From: Anita Gardner
Sent: 04 June 2018 14:32
To: Karen Parsons
Subject: FW: FW: 1-4 Holm Oaks F/1/18/DOC - updated drawing and calculations

Subject: RE: 1-4 Holm Oaks F/15/16/PL - updated drawing and calculations

My comments on the revised details:

Drawing
SURFACE WATER DRAINAGE LAYOUT DETAILS

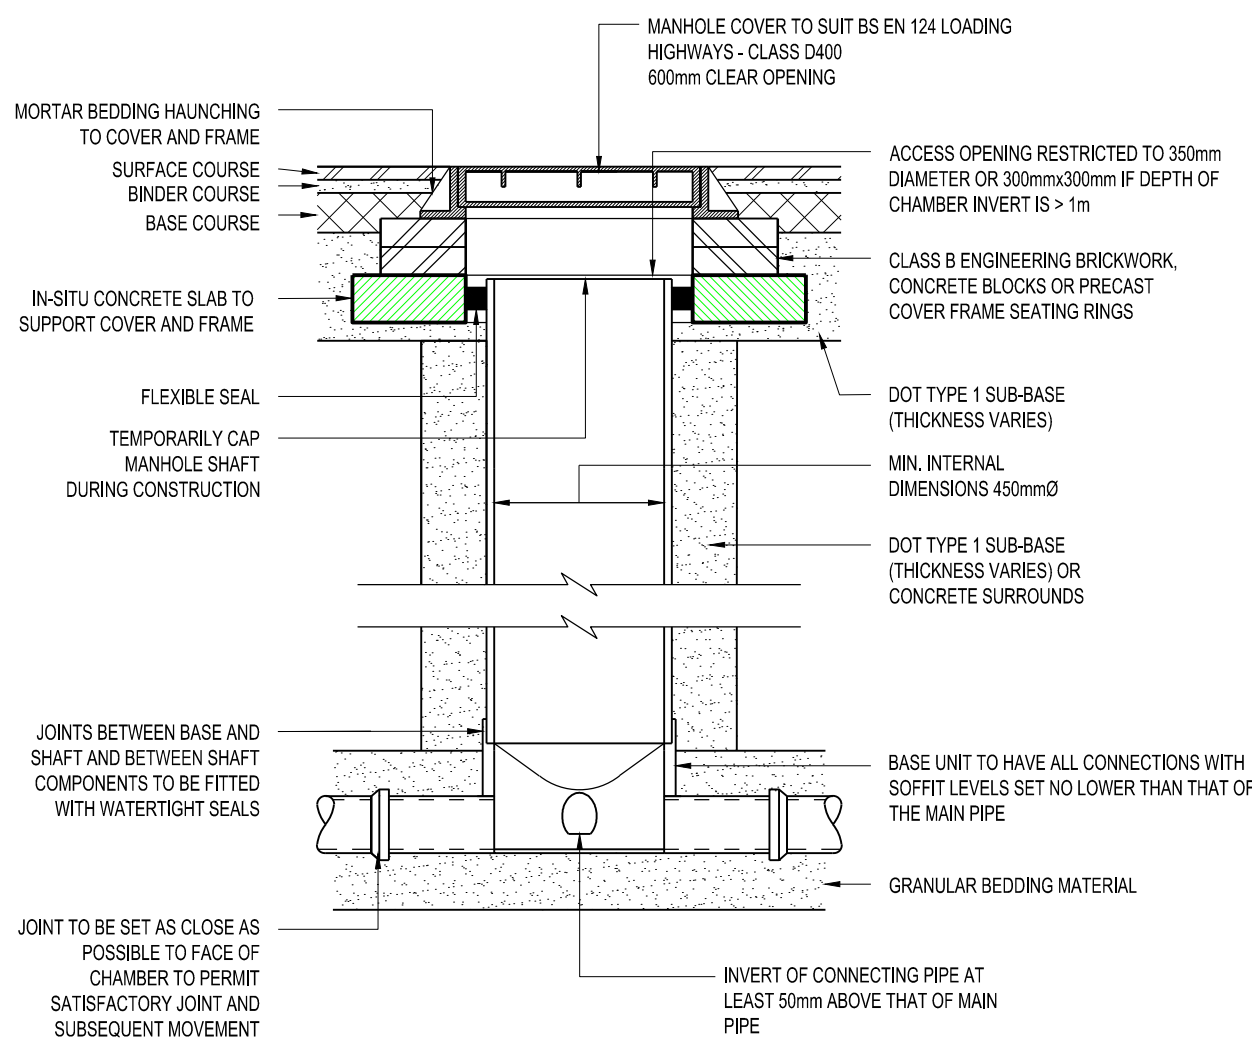
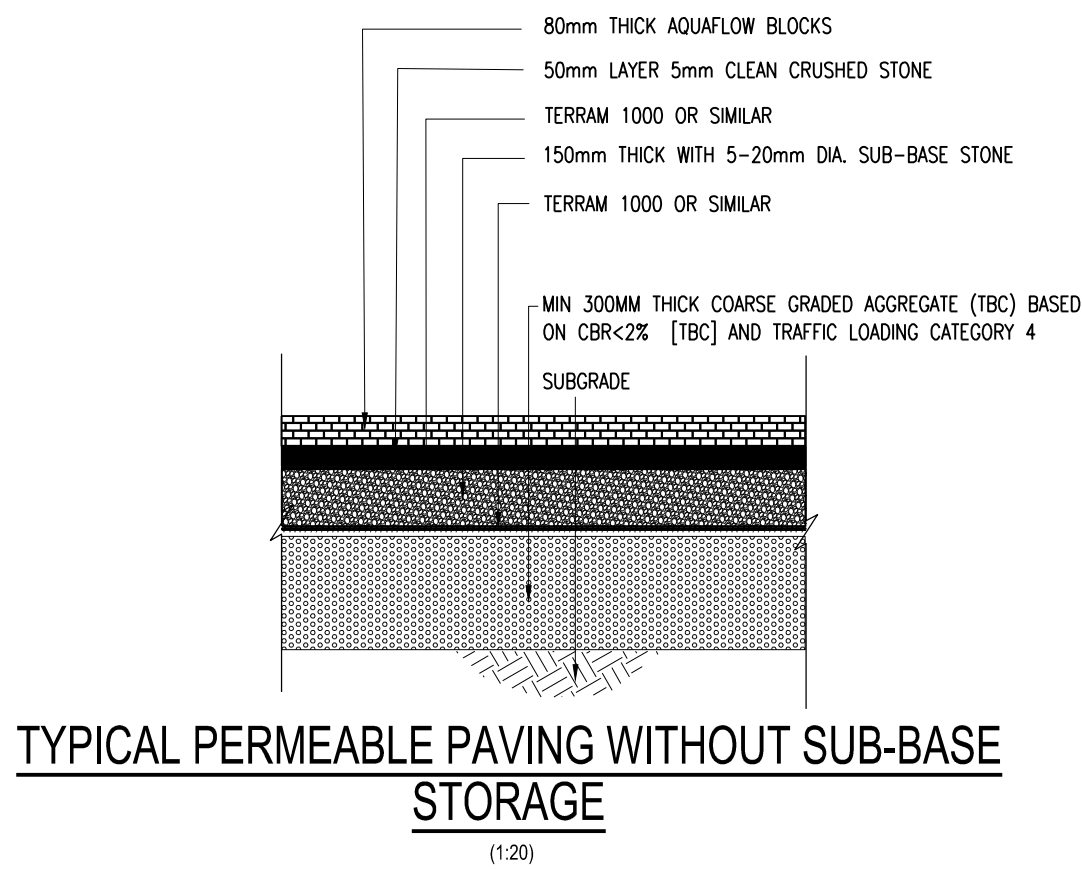
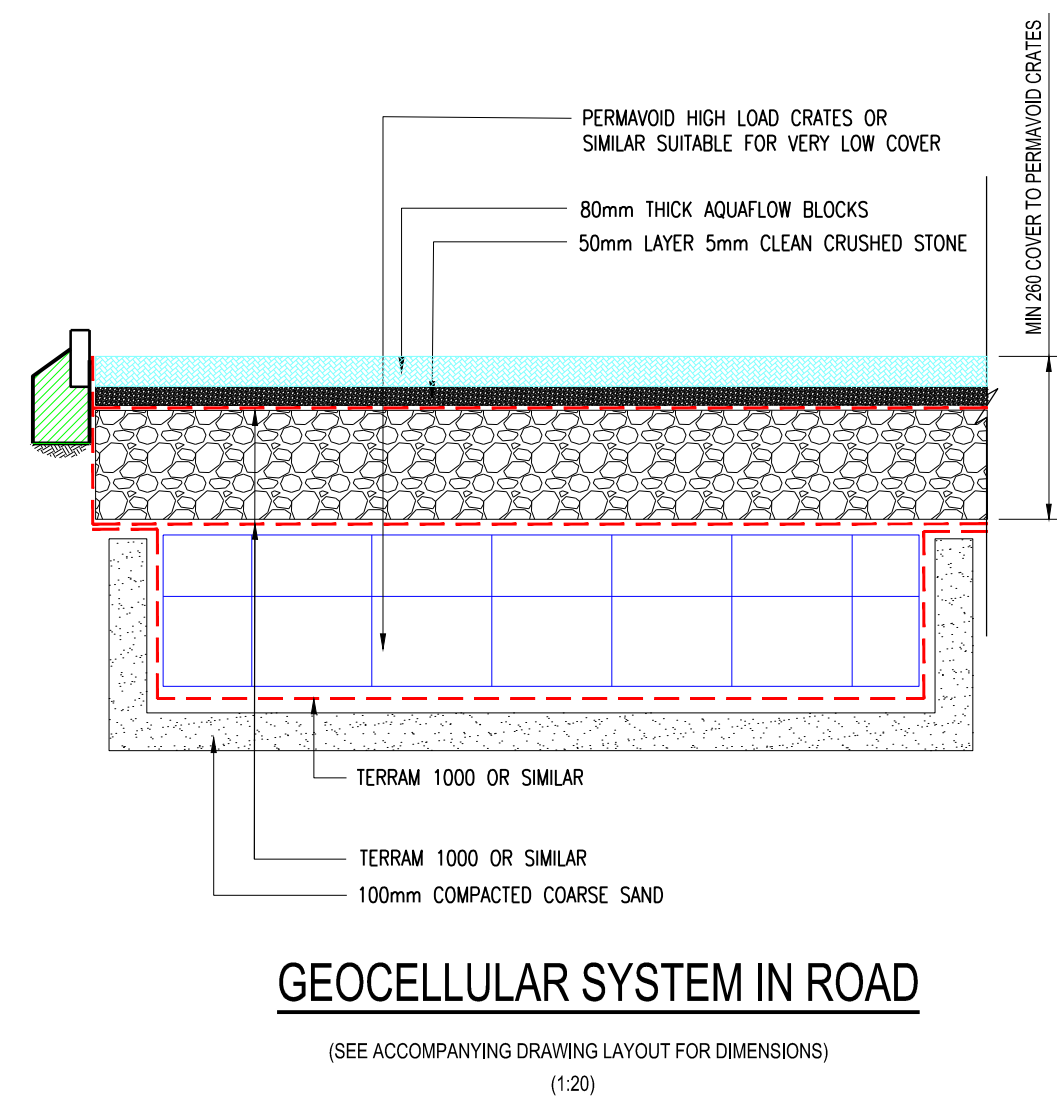
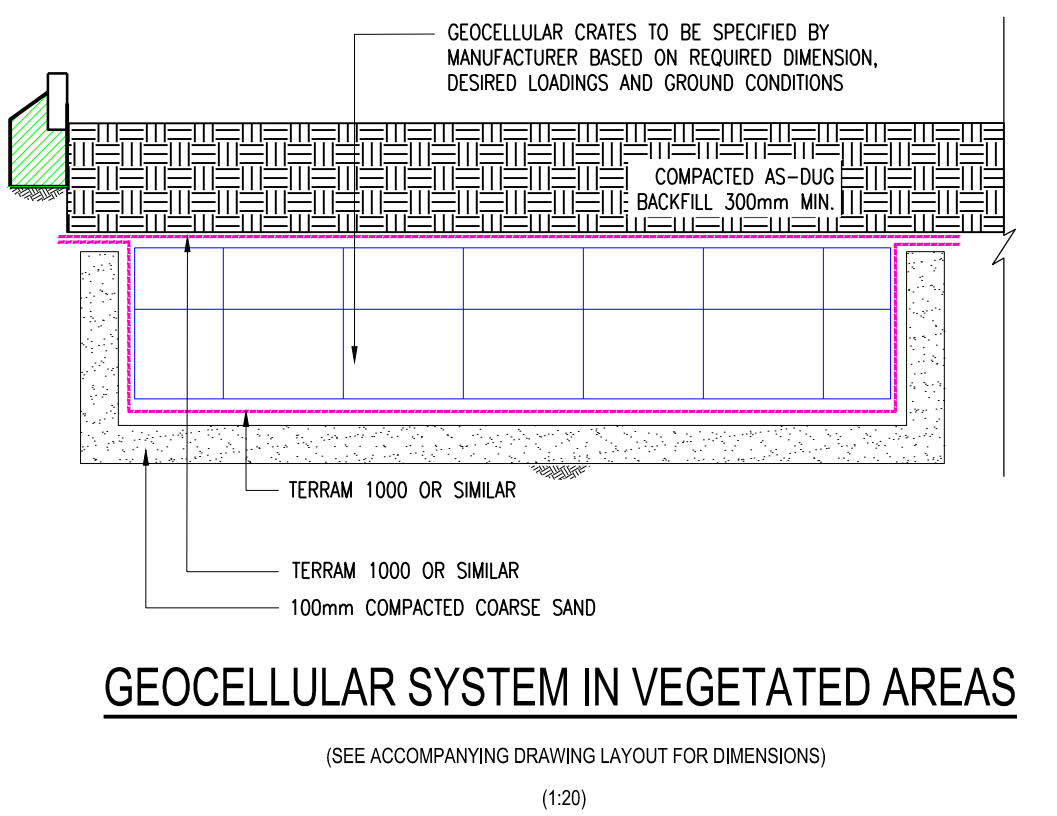
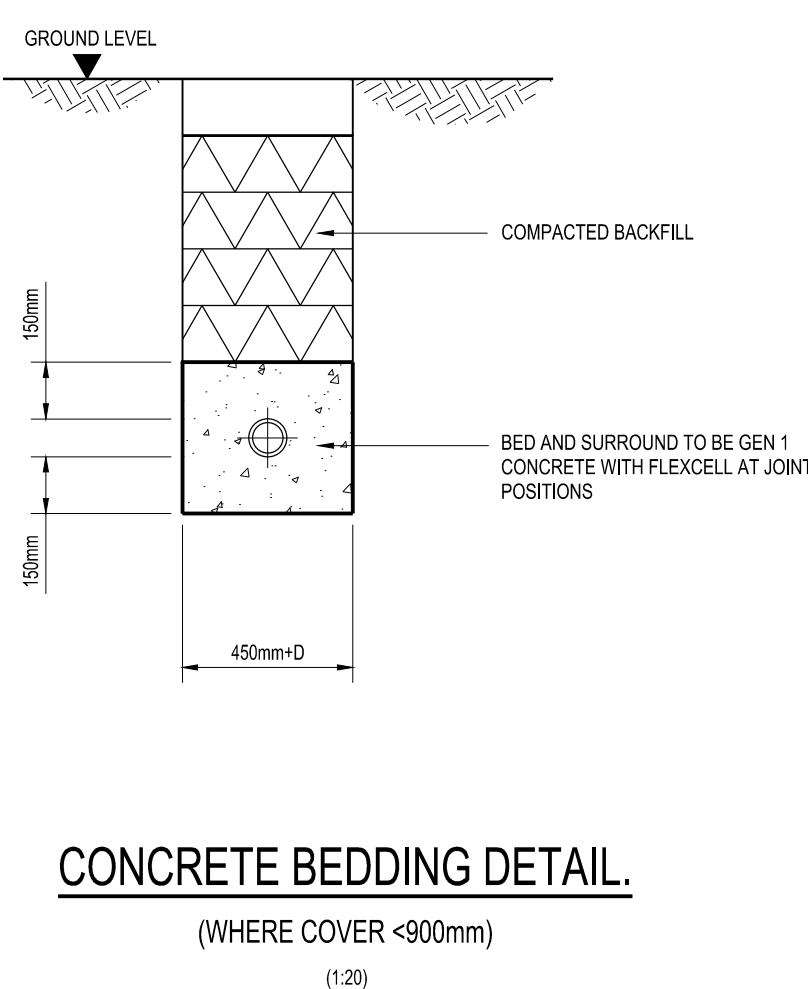
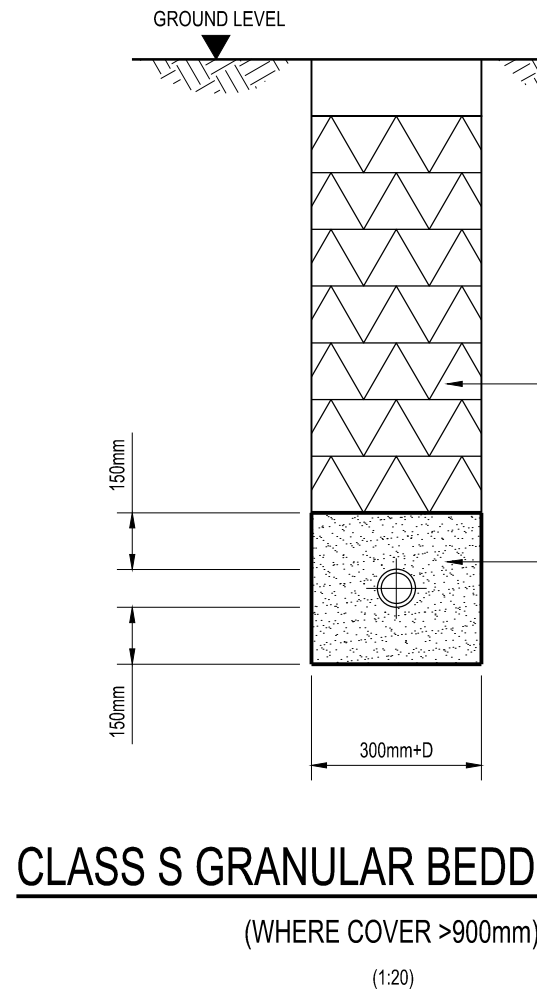
- Why has fleece been specified on all of the soakaways?
- Please ensure all construction detail drawings are specific and relate directly to the plan, i.e. silt trap types seem to be inconsistent.

- As stated previously please ensure that the ring soakaway has the brickwork on top of the cover slab minimised to maximise the depth of perforated rings above ground water level.

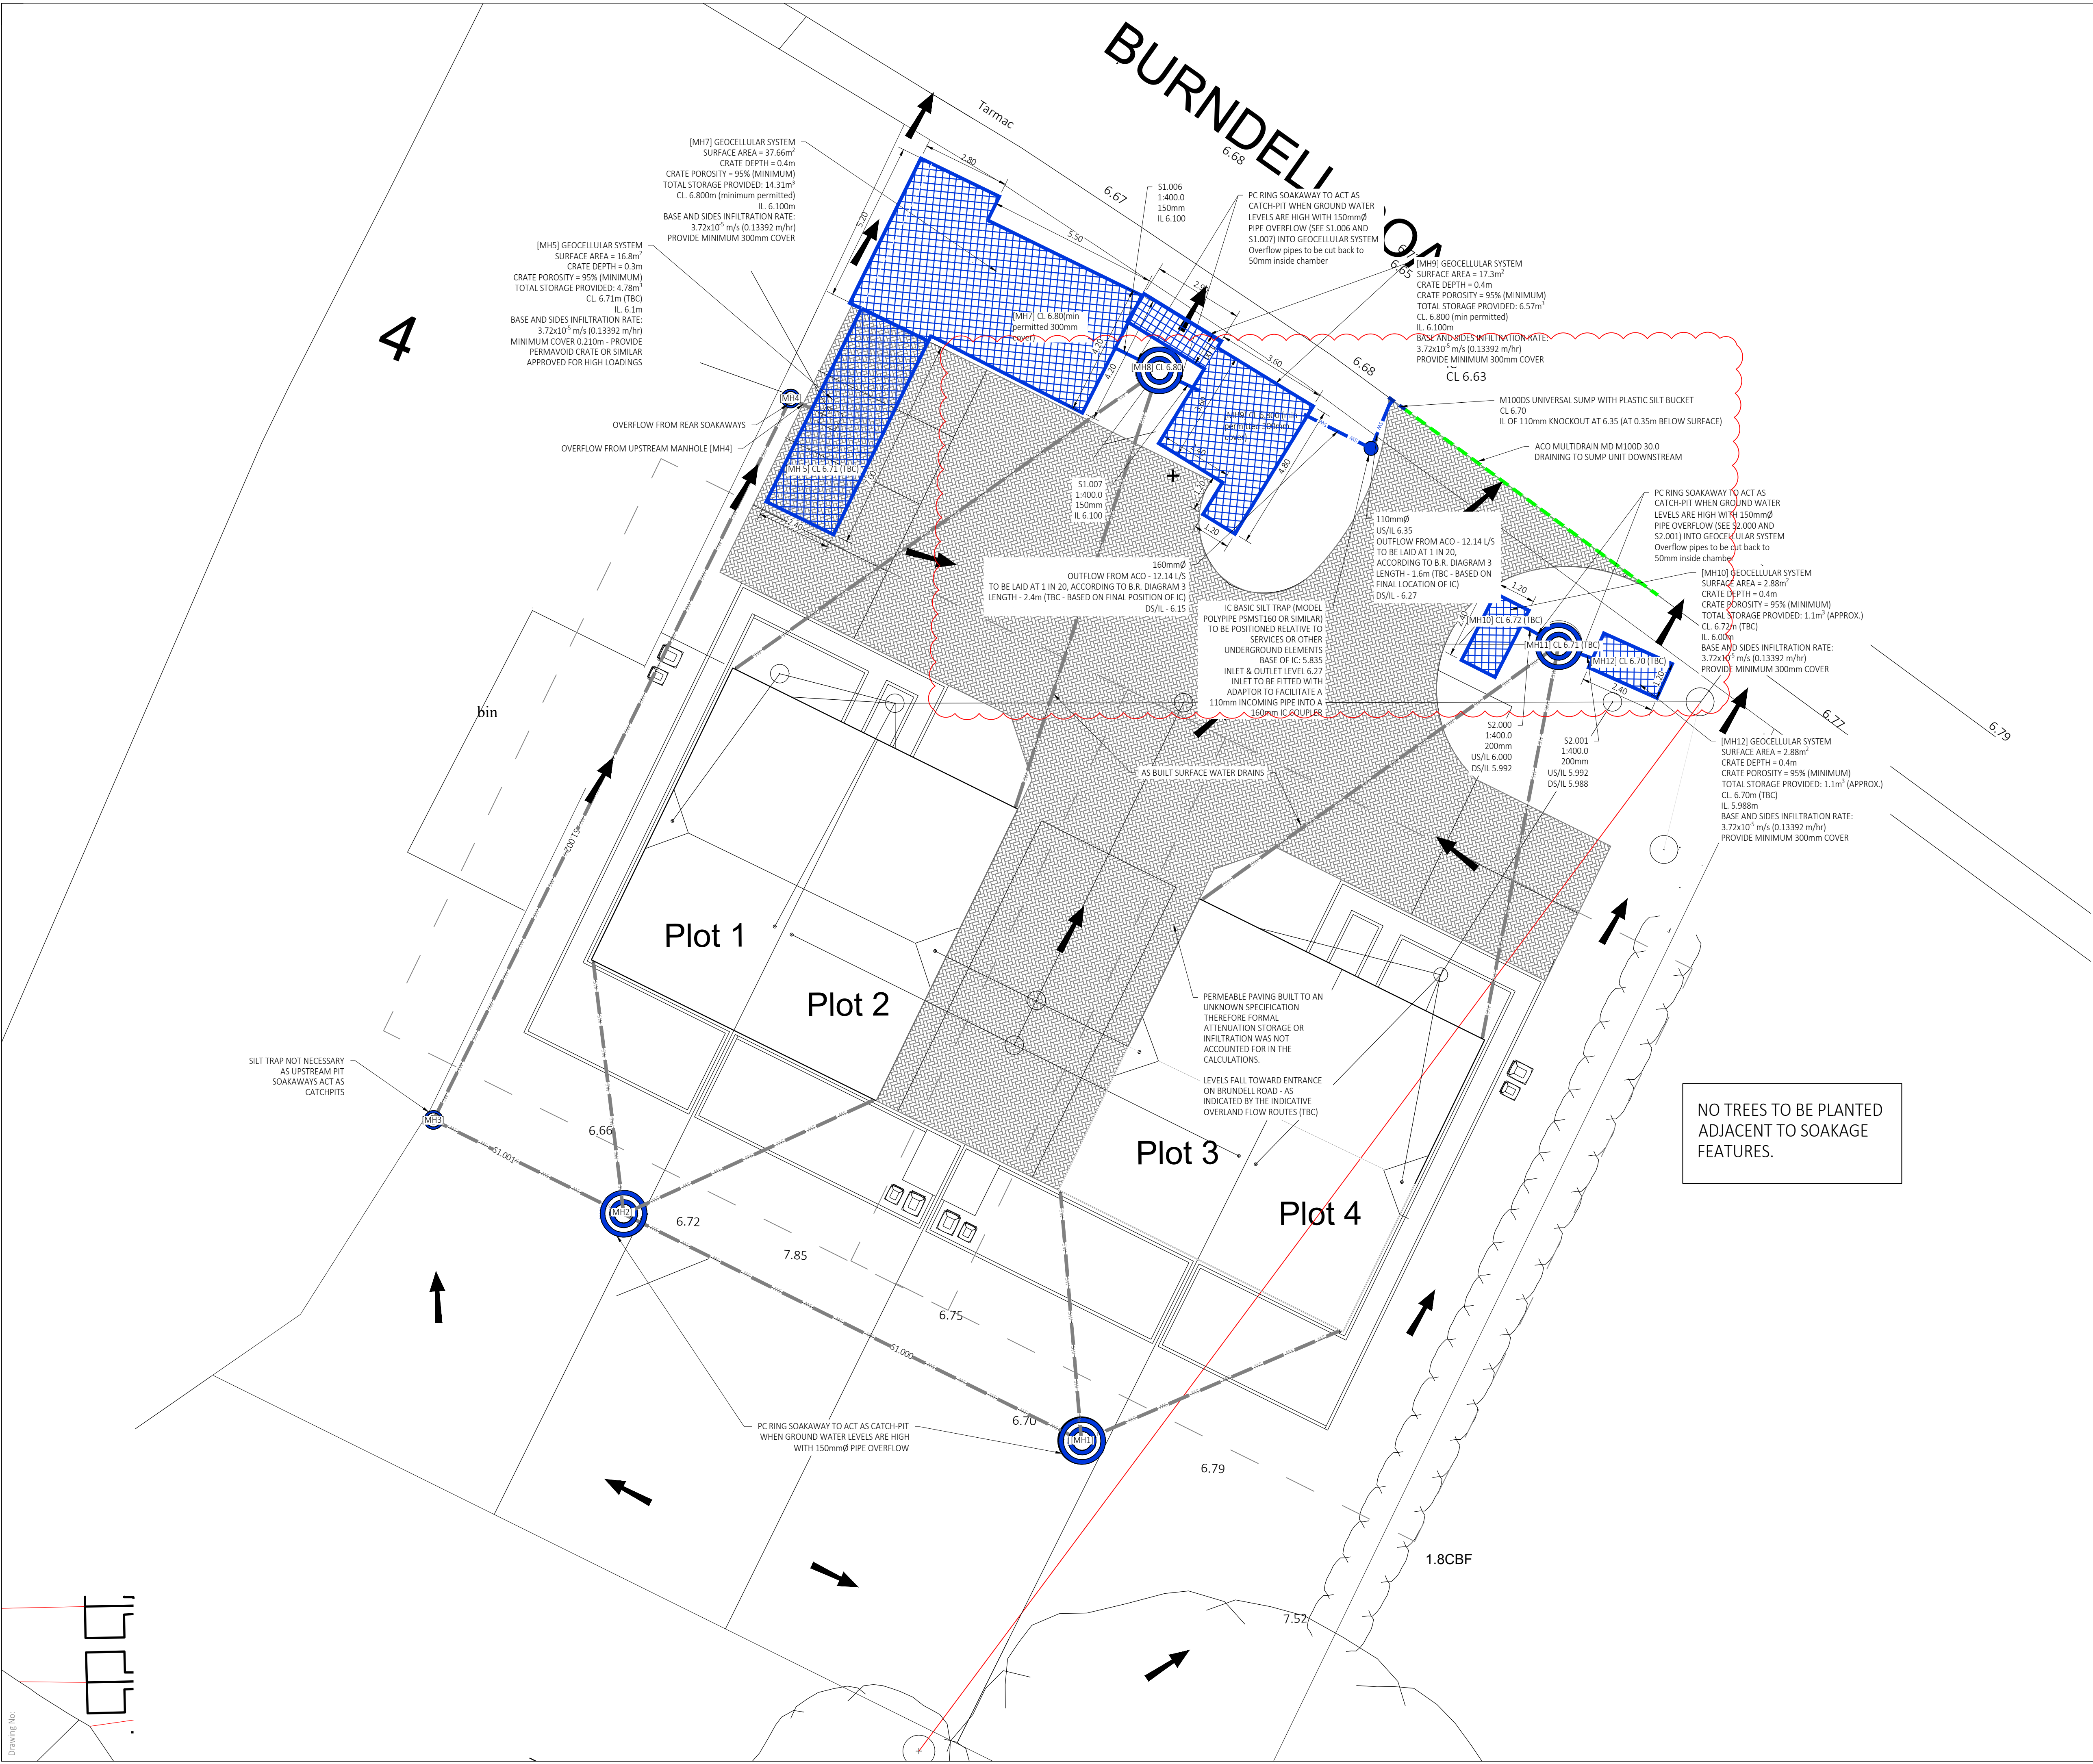
- I note that the invert levels of all soakaways specified are below the ground water level. Please raise these and all accompanying pipe work as required.

- The area of MH9 on the plan is less than the area specified in your calculations. The volume required from calculations exceeds that specified on the drawings.

- Please provide further details of how sufficient protection is going to be provided over MH5 to meet manufacturers specification as this is under a trafficked area.

- Please confirm that no part of the driveway is permeable.
- Protruding pipes need to be cut back to finish 50mm from the walls of manholes.
- Details which have been constructed and are to no longer be used need to be removed or filled in with suitable material and ring soakaways/ manholes made good.

- The pipe from the rear of the properties needs to be protected by concrete.
- No trees should be planted near to soakaways.
